Our reference: R/2021/10/A

Your reference: SSD 32927319

Subject: Advice on EIS - Powerhouse Ultimo Renewal - Stage 1 - SSD 32927319

1 BUILDING ENVELOPE 3D VIEW 2 - FROM SW CORNER  
Scale

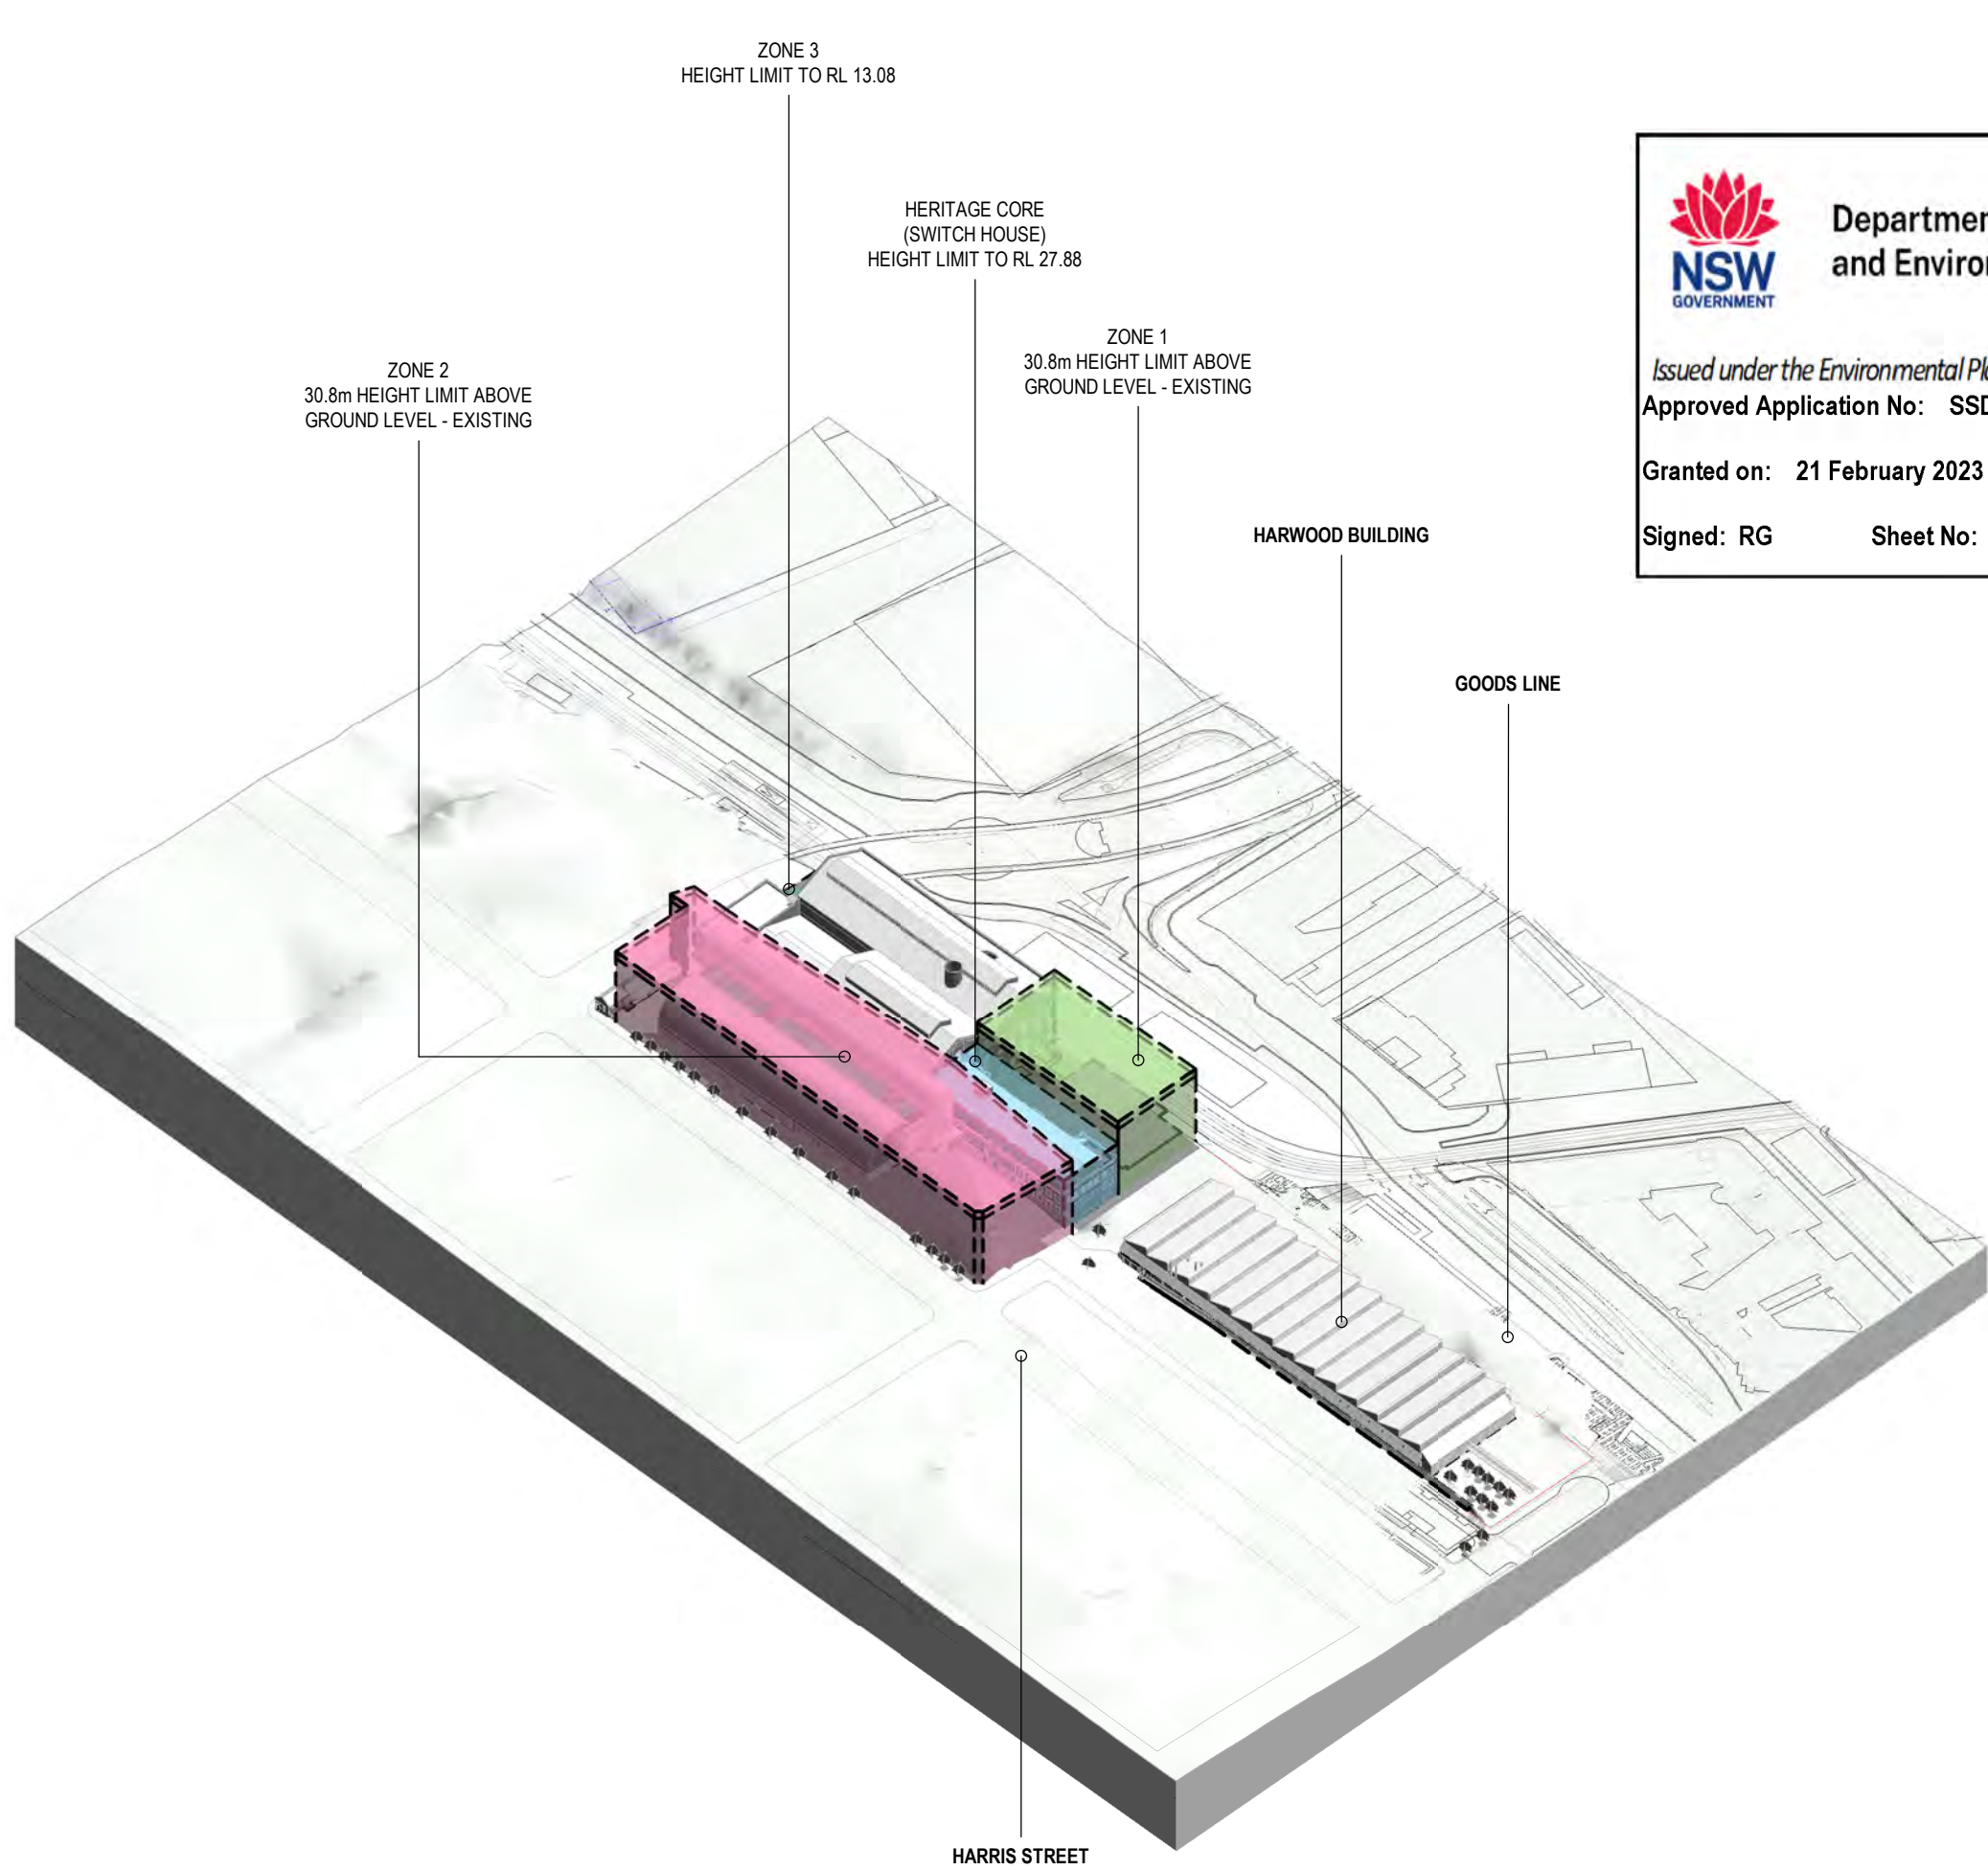
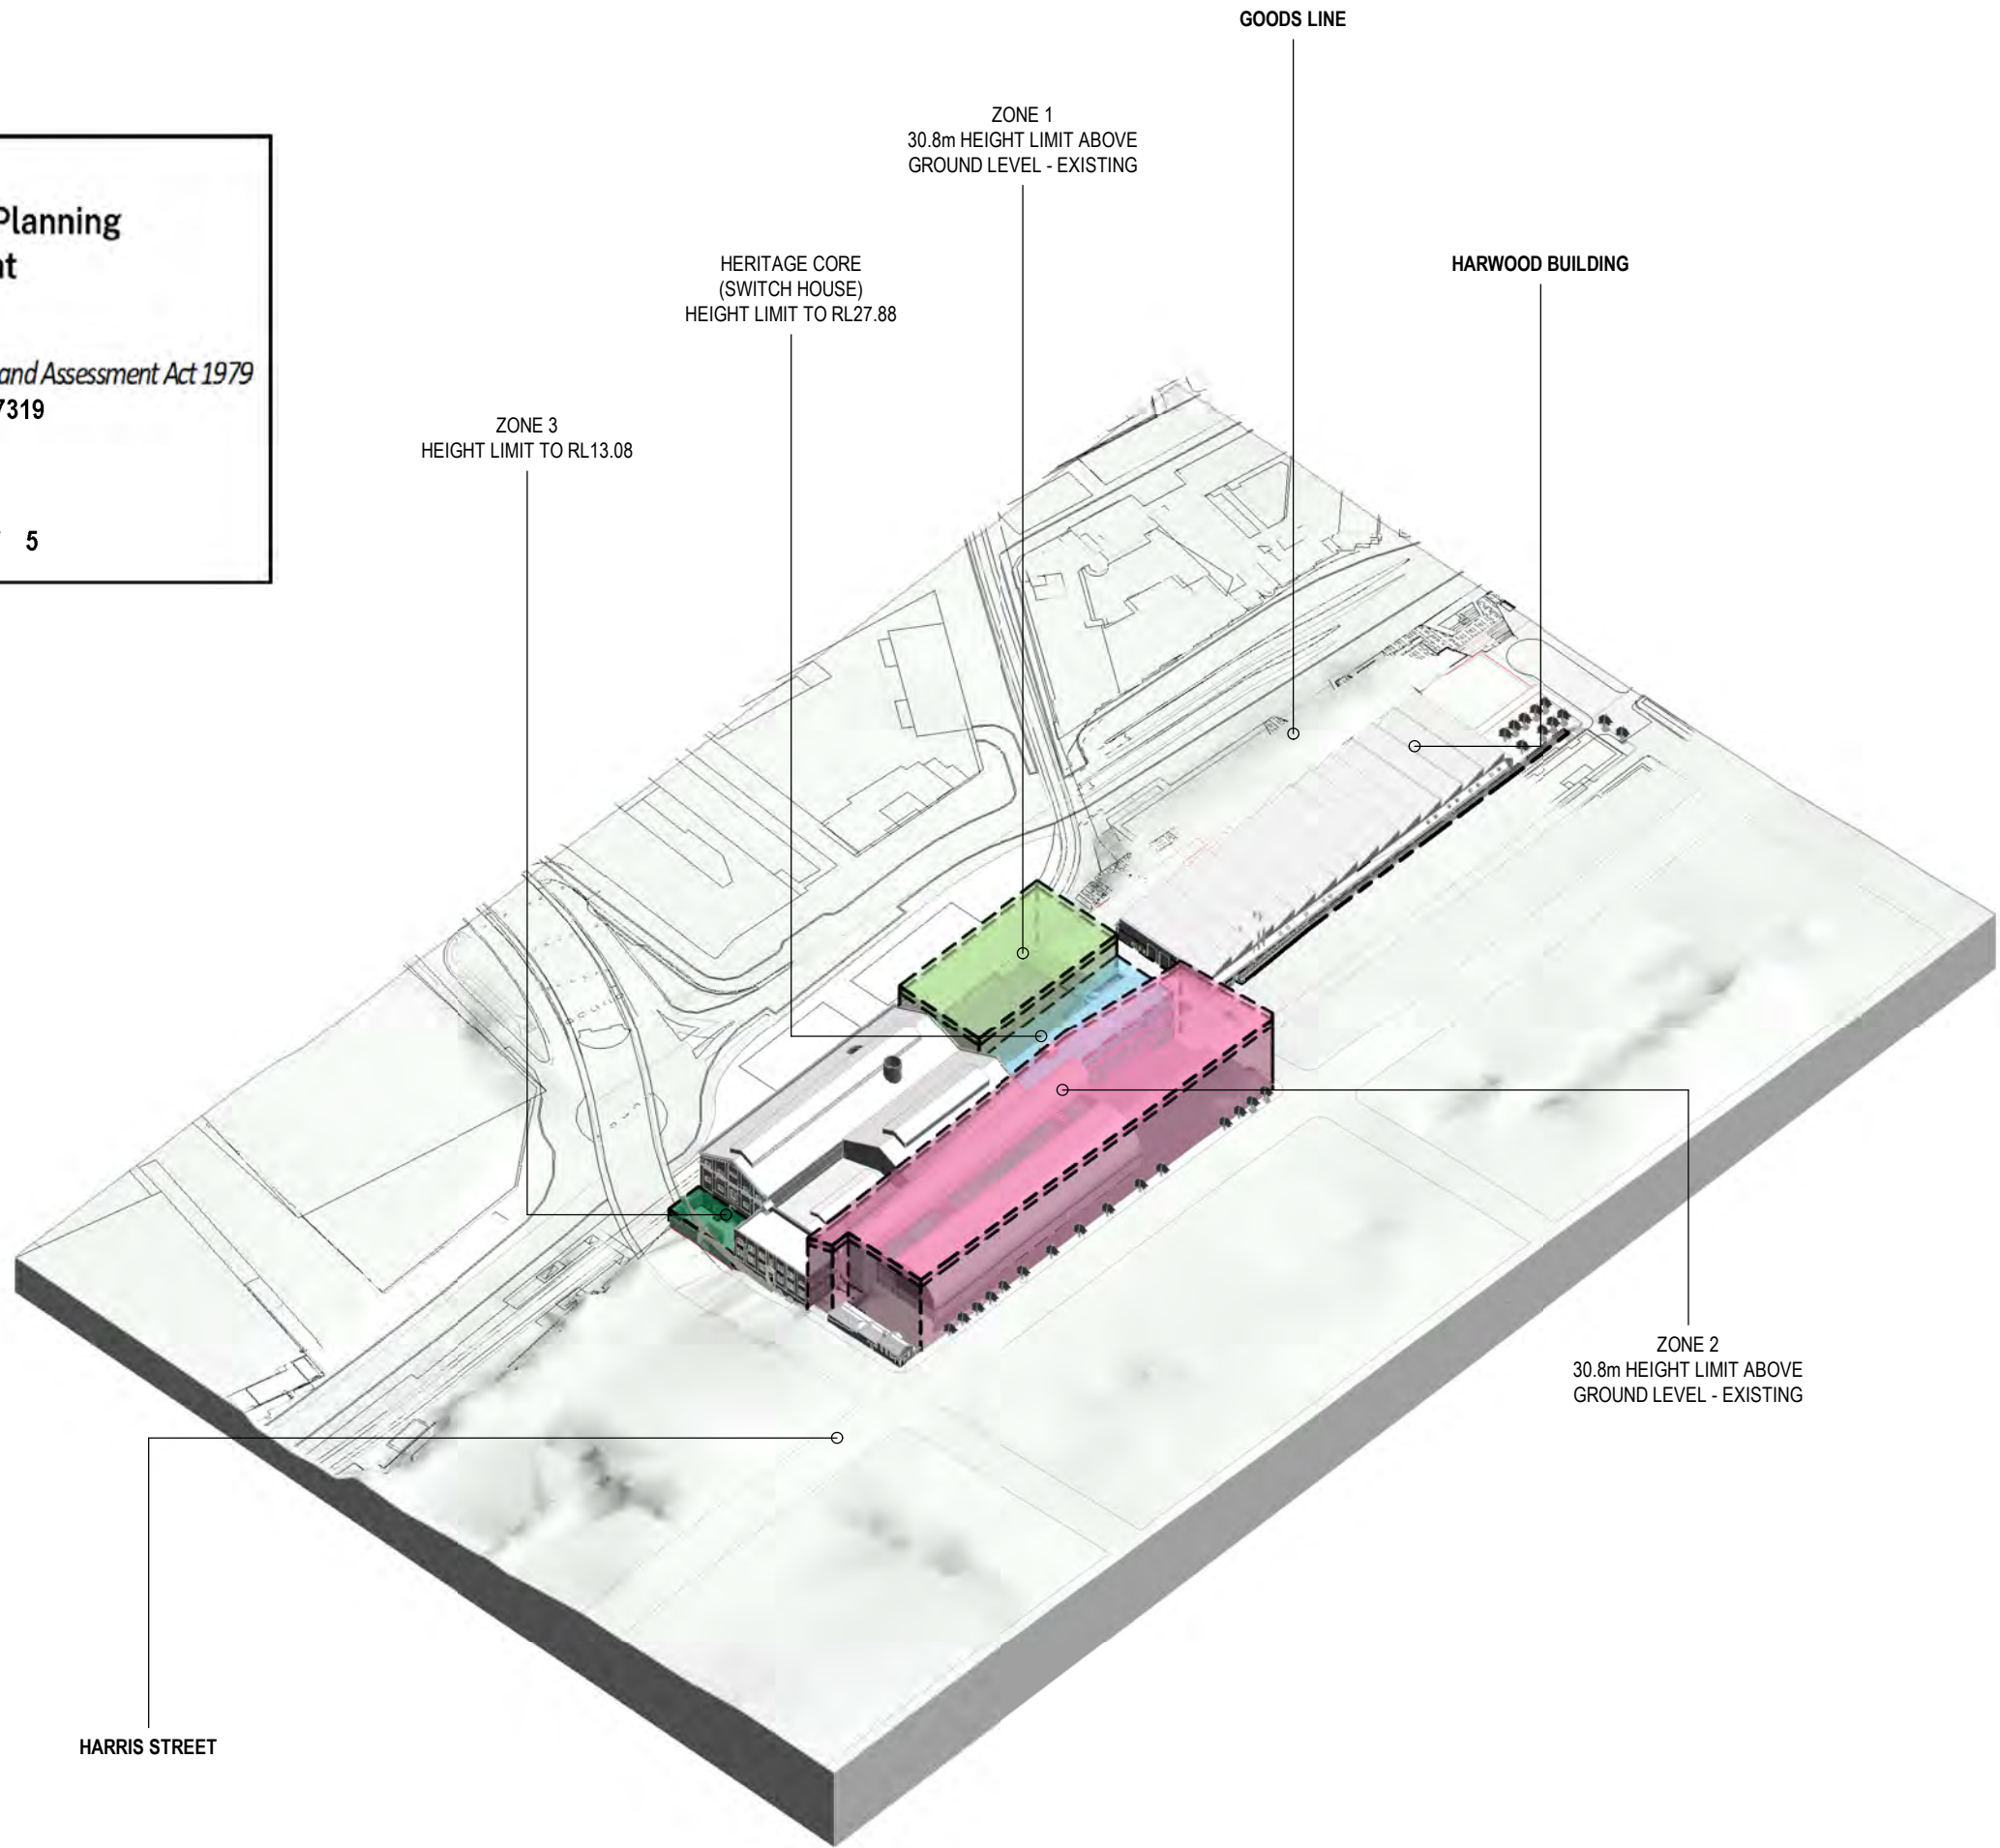
The submitted building envelope and massing drawings provides a series of coloured planning envelopes across the site. While envelopes surrounding and above items of no heritage significance are understood, clarification is sought as to why planning envelopes are identified above the existing heritage listed items. Whilst the envelopes above the heritage items only extend to or just above the existing heights of the buildings, clarity is needed as to the purpose of the inclusion of a planning envelope above the original roof form of the heritage listed buildings. Is development permitted or anticipated above the heritage listed buildings, or this is a tool to differentiate those envelopes where height can or cannot be explored. The City assumes that the heritage items being of local and state significance shall be retained in their current form and any development above their roof is to be avoided. Separate to this observation, the City has previously discussed with the Powerhouse forthcoming amendments to the LEP to allow the Powerhouse site(s) to be potentially eligible for an award of heritage floor space for its conserved heritage listed buildings. To be eligible for an award of HFS in the future, the heritage listed buildings should not be subject to works that would increase the external envelope and floor space of the building other than a minor increase to facilitate the adaptive re-use of the heritage building.

The concept application shows a required 3 metre setback of the lower levels of the new building facing Harris Street while upper levels are not set back and can potentially cantilever over the lower levels. This non-continuous vertical setback is not supported from an urban design perspective as it is not in keeping with the existing built form or desired future character of the streetscape of the locality. All buildings in Harris Street with the exception of the Community Centre and Library have a continuous vertical presentation to the street without overhanging upper levels. The existing Wran Building on the Powerhouse site is not regarded as an appropriate street frontage and is not supported as a precedent. Protruding upper levels above a lower setback will result in a potential building form that:

Overall, it is recommended that the UDR be updated to contain a clear set of principles against which a Design Excellence Strategy can respond. The submitted principles, objectives and guidelines are very general and loose as to not have meaning or something to respond to. The application needs clarification regarding the proposed building envelopes around existing State heritage items. Envelopes should be amended or annotated to remove doubt of any possible infill of the existing roof forms of the heritage listed buildings. Alternatively, possible building envelopes above existing heritage items should be removed from the drawings entirely.
